Wyoming Estates - Preliminary Plan

The Southeast Quarter of the Northeast Quarter of Section 33, Township 13 South, Range 64 West of the 6th P.M., El Paso County, Colorado

ALESSI and ASSOCIATES, Inc.
APPRAISERS • ENGINEERS • SURVEYORS
2989 Broadmoor Valley Road, Suite C
Colorado Springs, CO 80906
Tel: 719/540-8832
Fax 719/540-2781
The SE1/4 of the NE 1/4 of Section 33, Township 13 South, Range 64 West
6th Principle Meridian, El Paso County, Colorado
Job No.231137 Wyoming Estates Preliminary Plan DATE January 8, 2024

# Wyoming Estates - Preliminary Plan

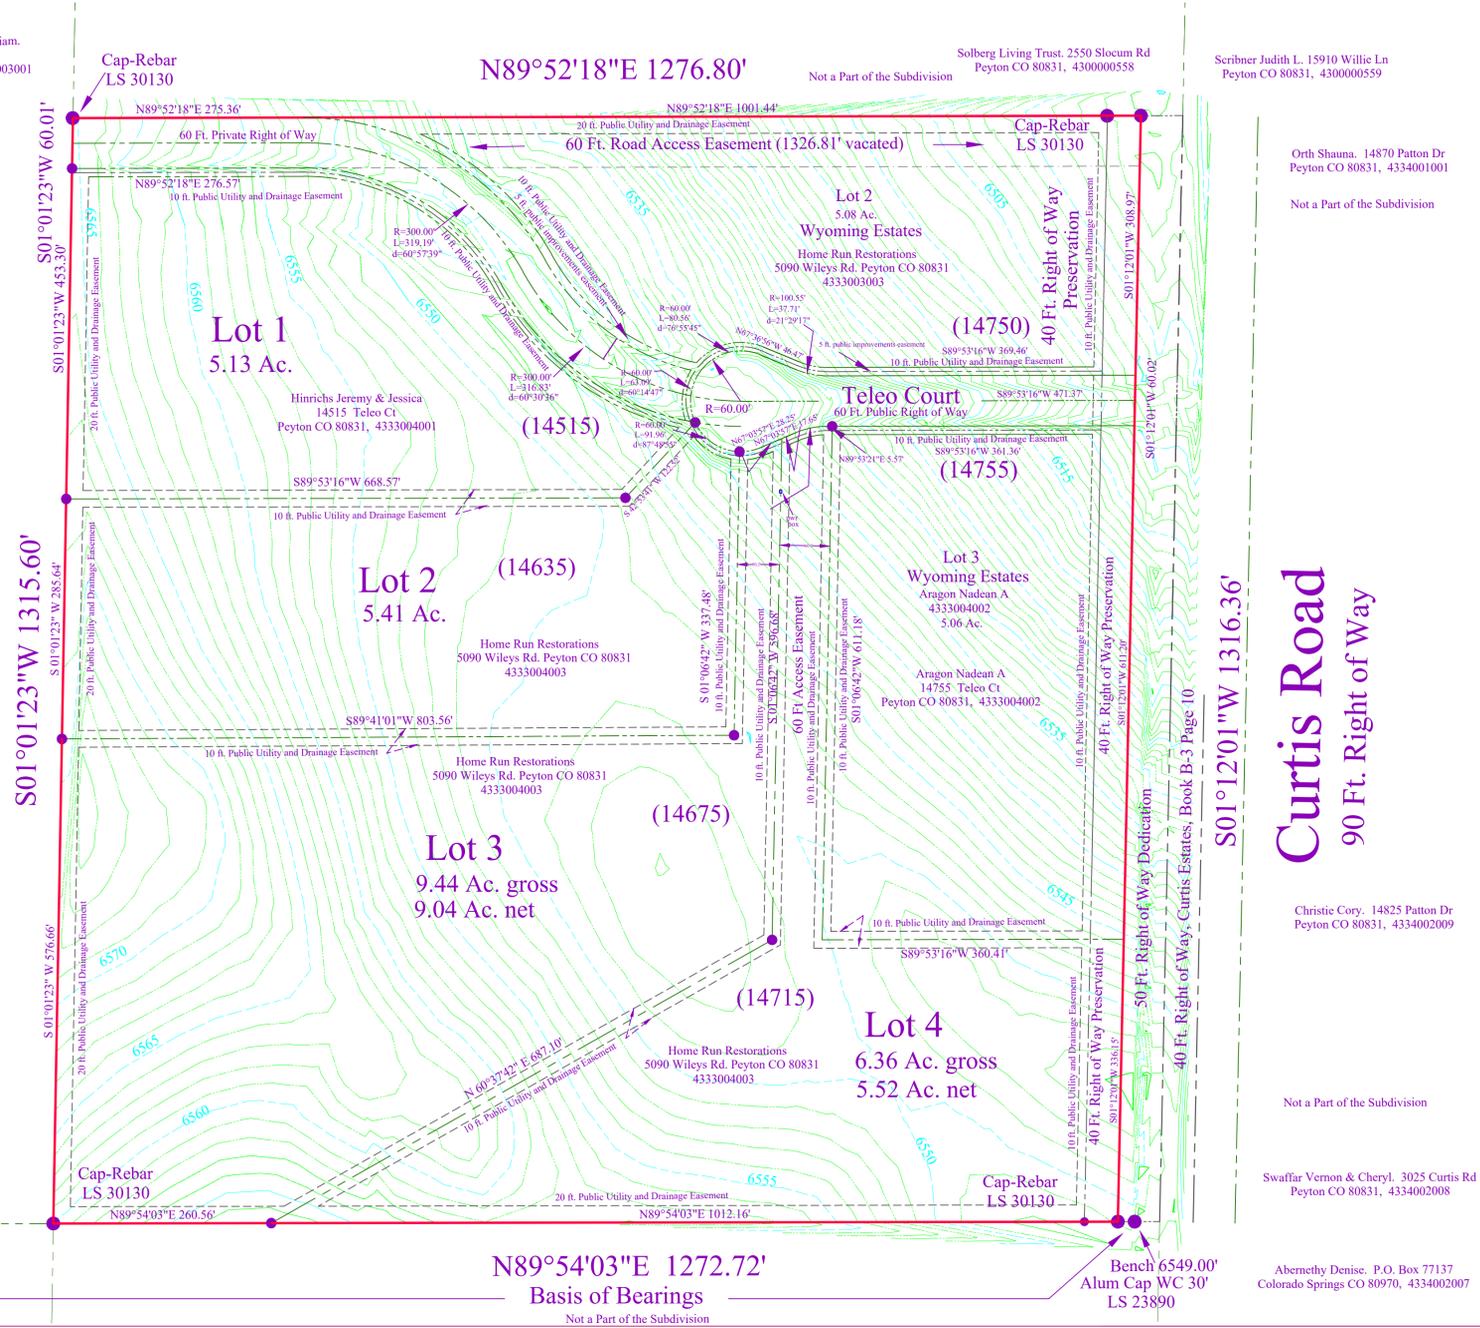
Previous comments not addressed from 1st and 2nd reviews. Easements are not depicted. Depict all easements (drainage, utility, etc.)

What is the purpose of these blank notes? Please remove these.

This note has been deleted. Please put it back. Developer shall comply with federal and state laws, regulations, ordinances, review and permit requirements, and other agency requirements, if any, of applicable agencies including, but not limited to, the Colorado Division of Wildlife, Colorado Department of Transportation, U.S. Army Corps of Engineers and the U.S. Fish and Wildlife Service regarding the Endangered Species Act, particularly as it relates to the listed species (e.g., Preble's Meadow Jumping Mouse).

You've also deleted the soils & Geology note. Please put it back.
